CONSULTATION UNDER TOWN AND COUNTRY PLANNING ACT 1990

Application Number	PL/2023/01546/MINFHO
Address	Lyndhurst 71 Main Road Meriden Solihull CV7 7LP
Proposal	New front car parking area with access from main road and erection of balustrade/handrail to the front of the property.
Case Officer	Lou Randall

Date comments sent	02/08/23
Name of consultee department	Highways
Consultation response author	Gurdip Nagra

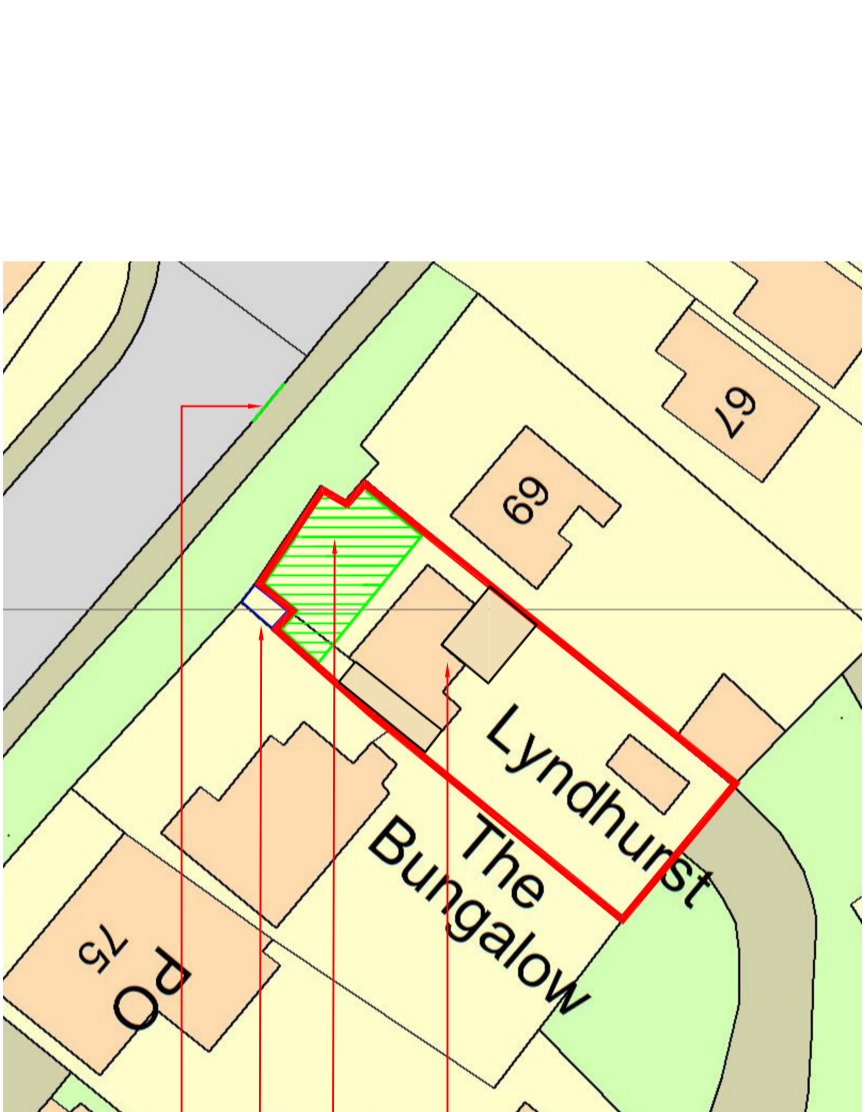
Comments: (Please explain the reason for your response)
<p><u>Proposal</u> Planning consent for a front car parking area with access from Main Road was granted under application no. PL/2019/01487/MINFHO and this proposal is a resubmission for parking to the front of the property.</p> <p>The Highway Authority is satisfied that the proposed vehicular access meets the required standards, and will not have a detrimental impact on public highway safety, or on the operation or capacity of the local highway network.</p>
Further information required (if applicable): (Please explain the reason for your response)
Amendments recommended (if applicable): (Please explain the reason for your response)
Recommended conditions (if applicable):

1. The access to the site for vehicles shall not be used until a public highway footway crossing has been laid out and constructed in accordance with the standard specification of the Highway Authority.

2. The access to the site for vehicles shall not be used in connection with the development until it has been surfaced with a bound material for its entirety, as measured from the near edge of the public highway carriageway.

3. The gradient of the access for vehicles to the site shall not be steeper than 1 in 20 for its entirety, as measured from the near edge of the public highway carriageway.

4. The access to the site shall not be constructed in such a manner as to reduce the effective capacity of any drain or ditch within the limits of the public highway.

5. No gates/barriers/doors shall be erected at the entrances to the site for vehicles.
